**WEST SUSSEX COUNTY COUNCIL
STRATEGIC PLANNING CONSULTATION**

SUBJECT: EP/137/11 - To remove the worn out metal gates to the entrances, to replace with oak gates and oak post and rail fences. The plans include soft landscaping and re-enforced grass paths for pedestrian and wheelchair access. Each gate will have a signboard "The Willowhayne" approximately 600mm x 400mm. Gates will be positioned North end of Angmering lane, North end of The Ridings, and the East end of Tamarisk Way. This application also falls within the parish of Rustington.

Willowhayne Estate Entrance Gates, North End Of The Ridings & Angmering Lane, East End Of Tamarisk Way, East Preston, West Sussex

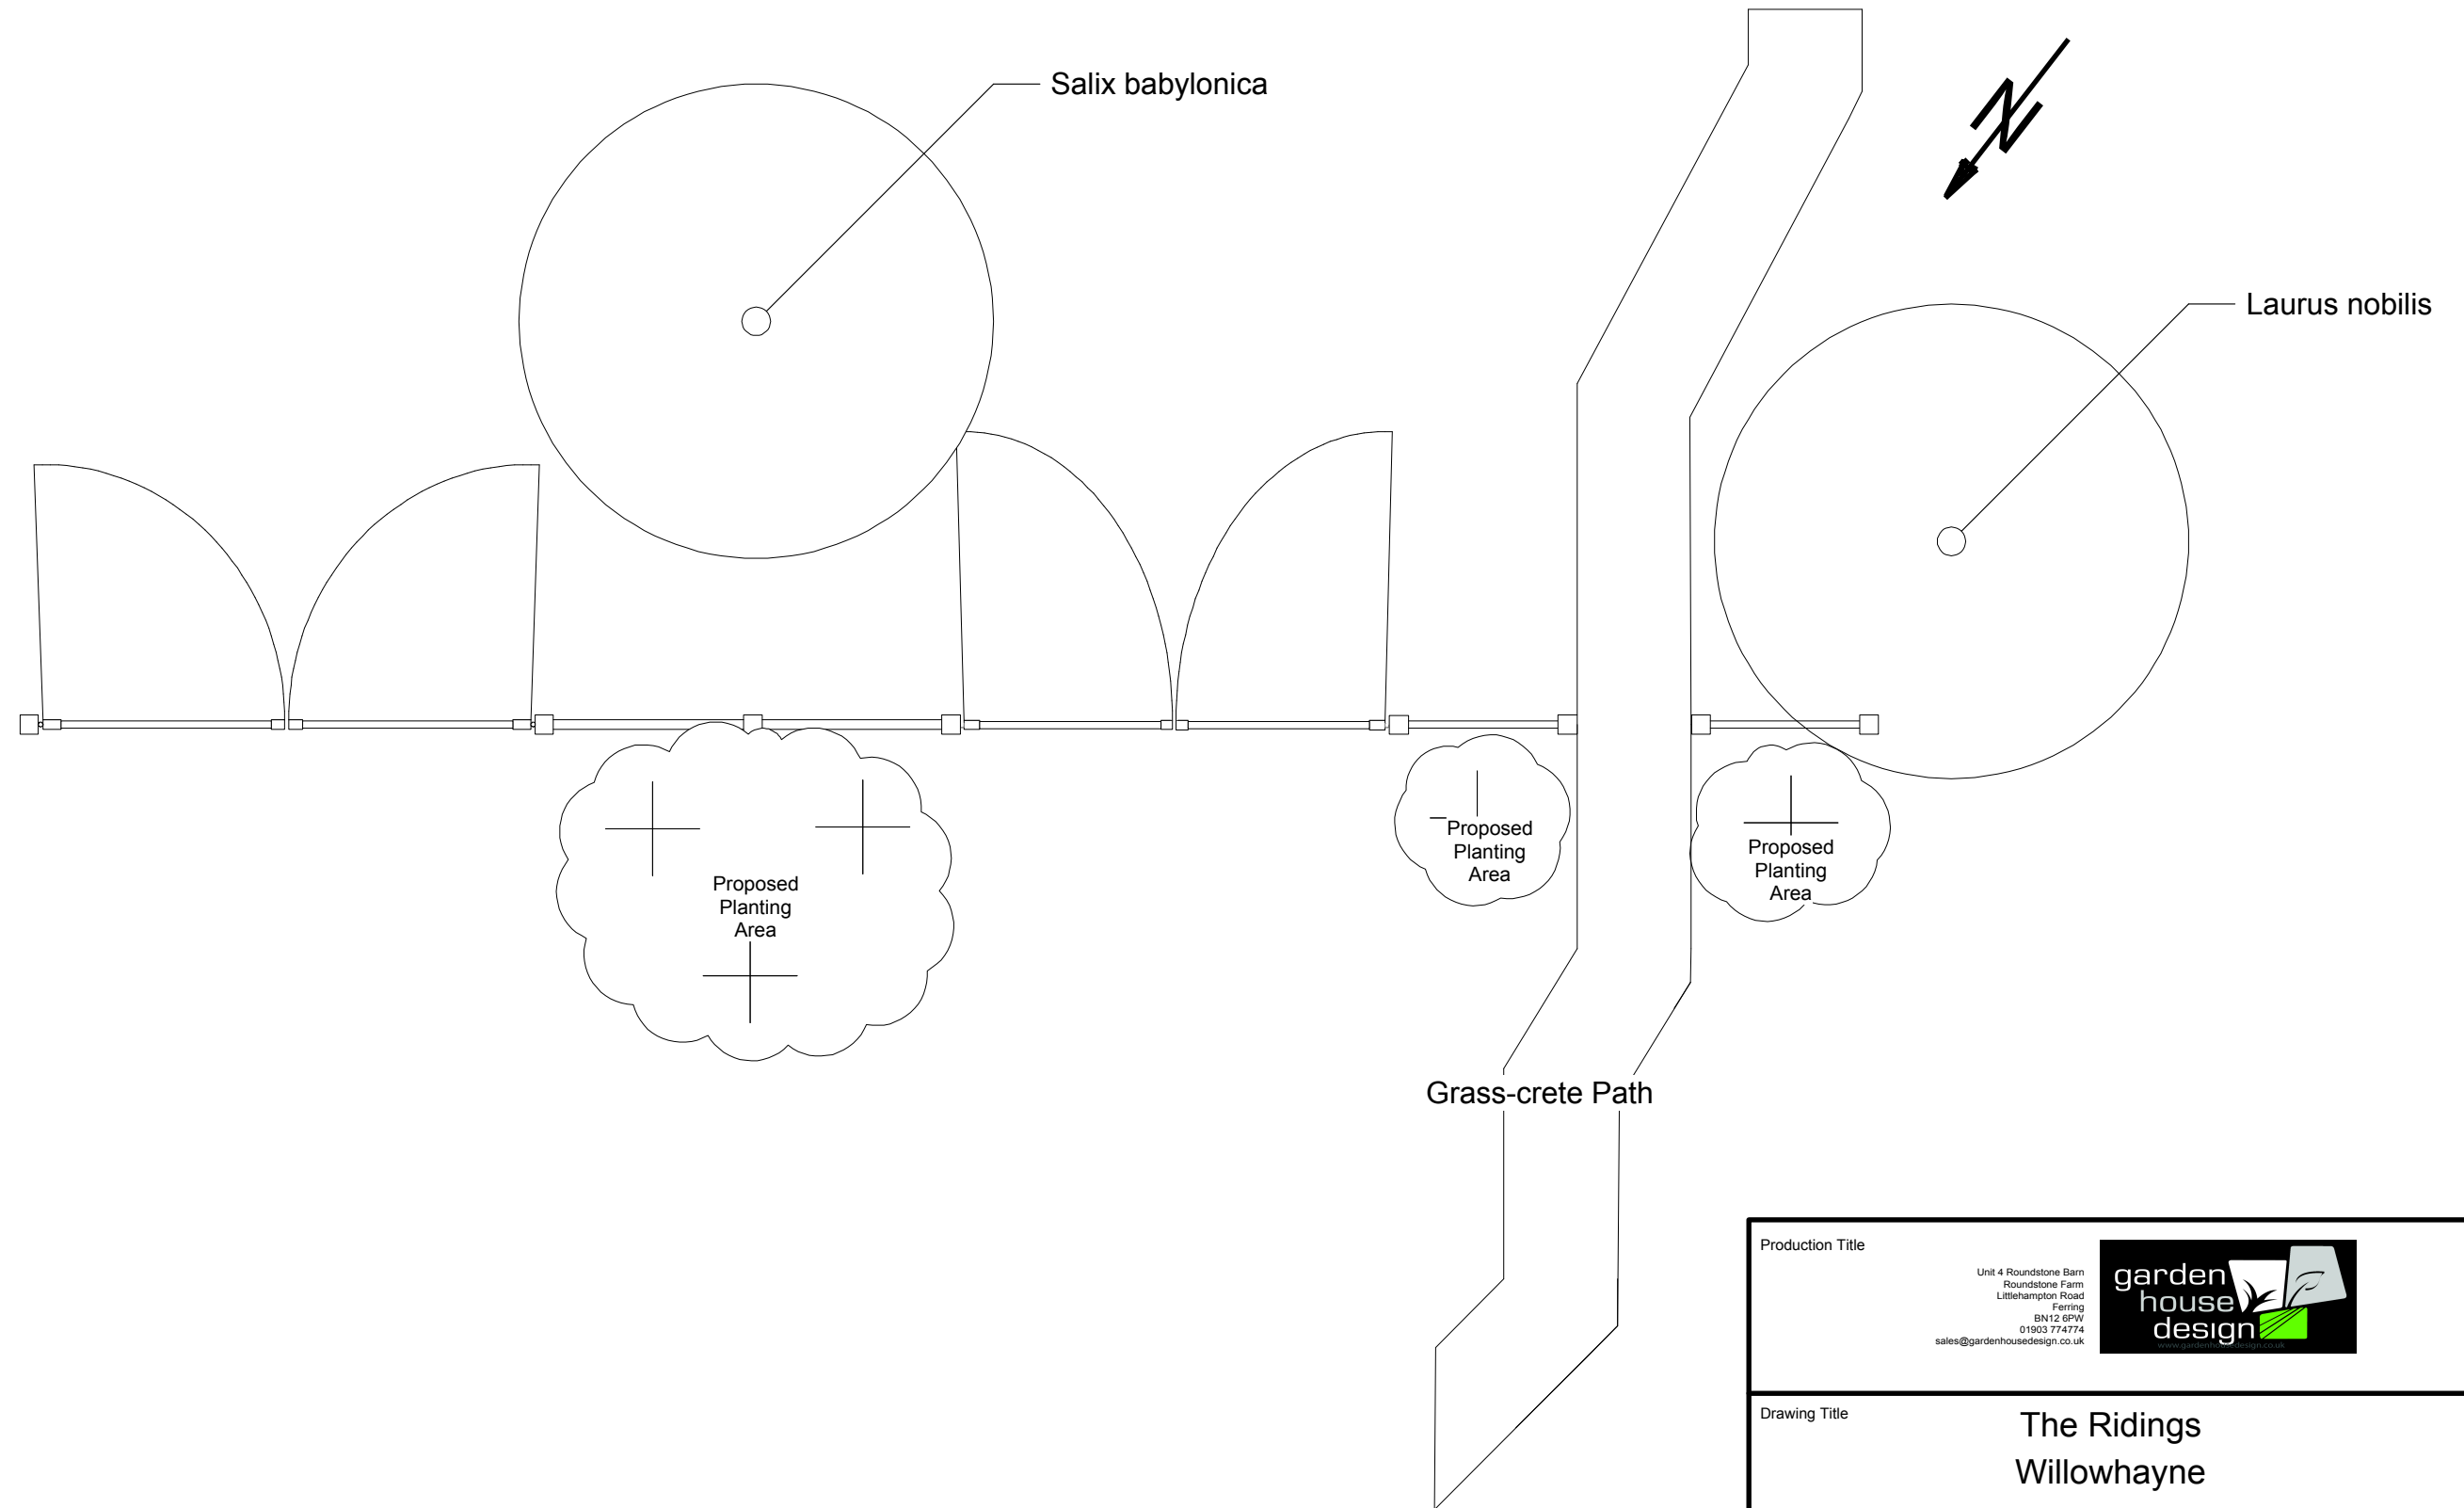
From the information submitted it is apparent that the proposal is to replace 3 sets of existing gates, as was the case with the 2011 application. Again the proposed gates all appear to be proposed in locations under the applicants' control. I would like to bring to the attention of the applicant that the proposed planting areas for The Ridings site and Angmering Lane do appear to be on land designated as public highway. The applicant would be required to contact the Costal Team Area Engineer to obtain formal permission for this planting.

It is also shown that the gates will open inwards of the site which is a requirement for gates such as these.

As we advised in 2011, the applicant would be required to provide signage remote from the highway, indicating "in" and "out" to avoid any confusion, specifically at the Angmering Way and The Ridings sites.

If the LPA are minded to approve this application a condition securing "in" and "out" signs should be included.
